From: Simon Davis
Sent: 12 August 2019 12:46
To: [REDACTED]
Subject: BR/125/19/PL 1-2 The Parade, Argyle Road

project title		date	project no
1-2 Argyle Road, Bognor Regis		08-2018	1810
drawing title	scale	drawing no	Guy Walker Architects New Olives, High Street, Uckfield, East Sussex TN22 1QE. Tel: 0779 9061715
Existing and Proposed Street Scene	1:50@ A3	PL04	
		status	revision no.
		Planning	/

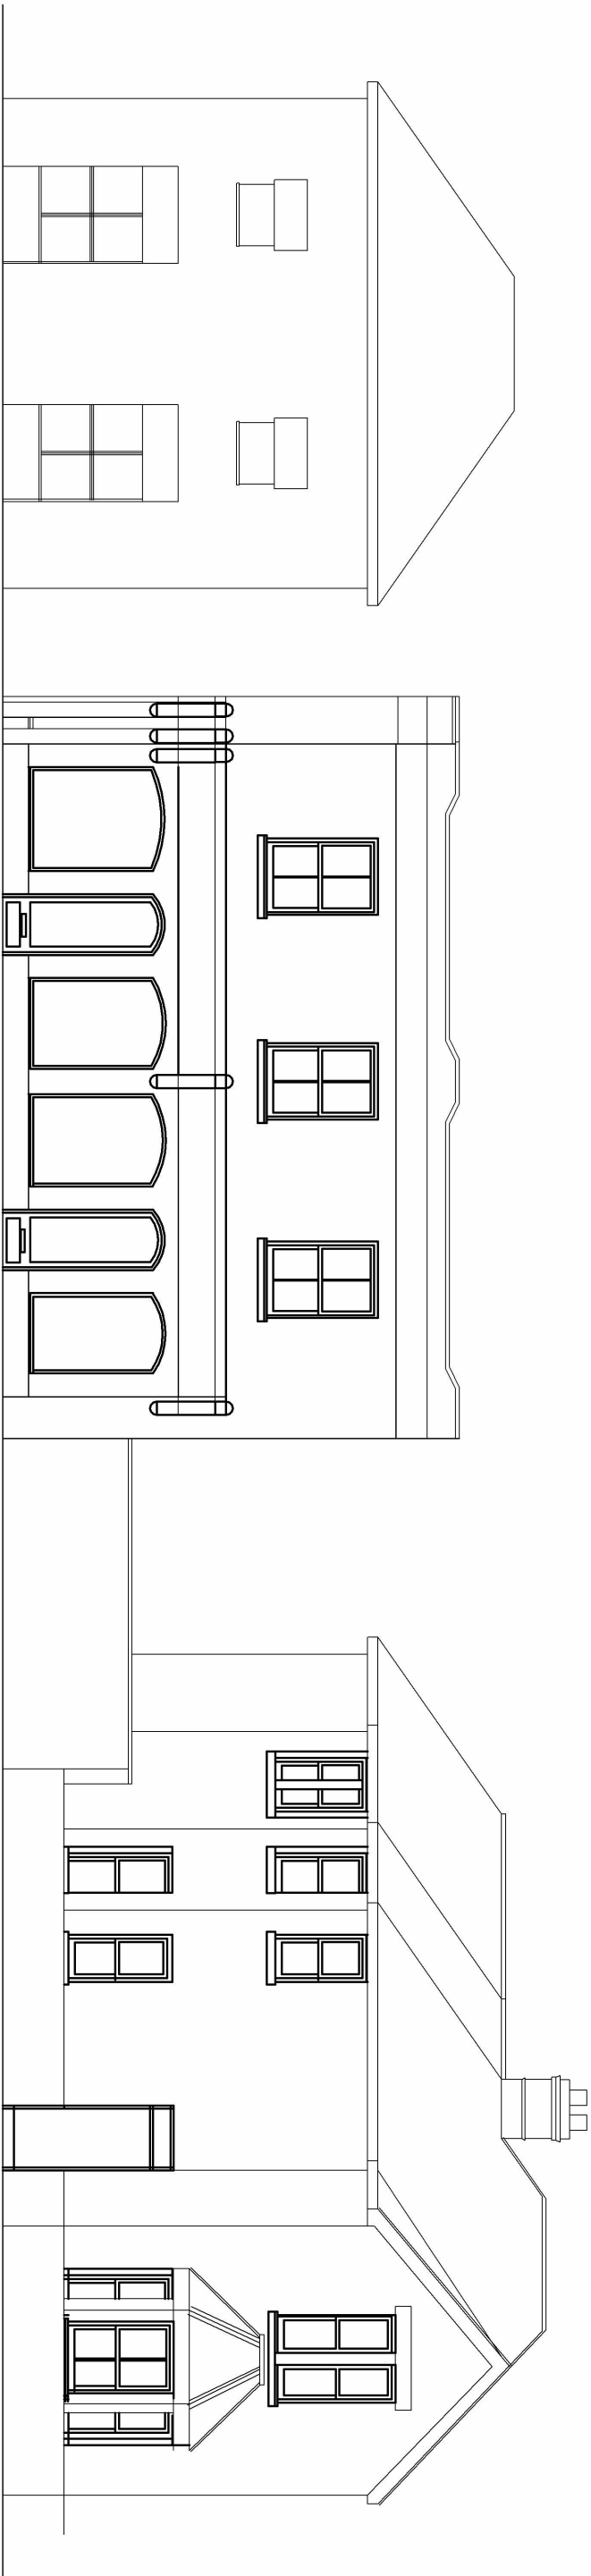
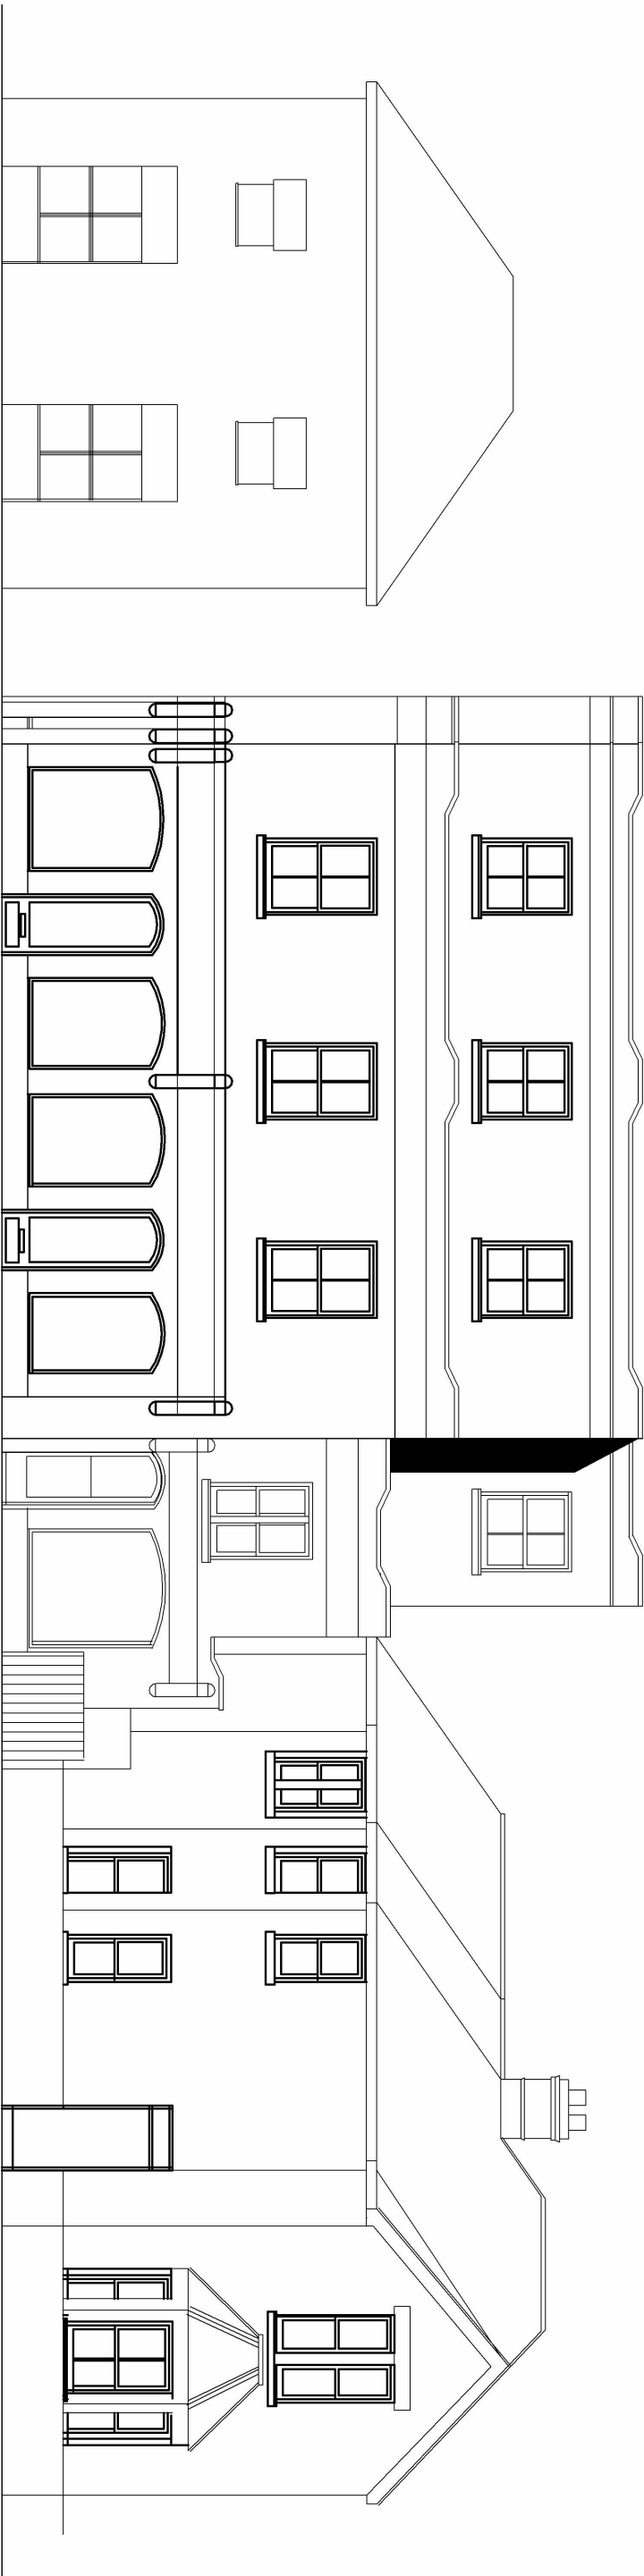
I write regarding this application. I have now made my assessment and must advise that we will be recommending this application for refusal. Our main reason for this is that the proposed additional storey will result in the building dominating the immediate streetscene and being out of character with what I consider to be the predominantly two storey form of buildings surrounding the site. I also have concerns regarding the impact of the side two storey extension on the windows on the neighbouring building to the south and the impact of the additional floor on the amenity of gardens to the east and also the same neighbour to the south. Finally, you should note that we would be looking for the flats to as a far as possible meet the 37m2 internal floor area as set out in the national space standards. I am not able to measure from the plans (please provide measurements) but consider that the new studio flats do not look like they will meet this requirement.
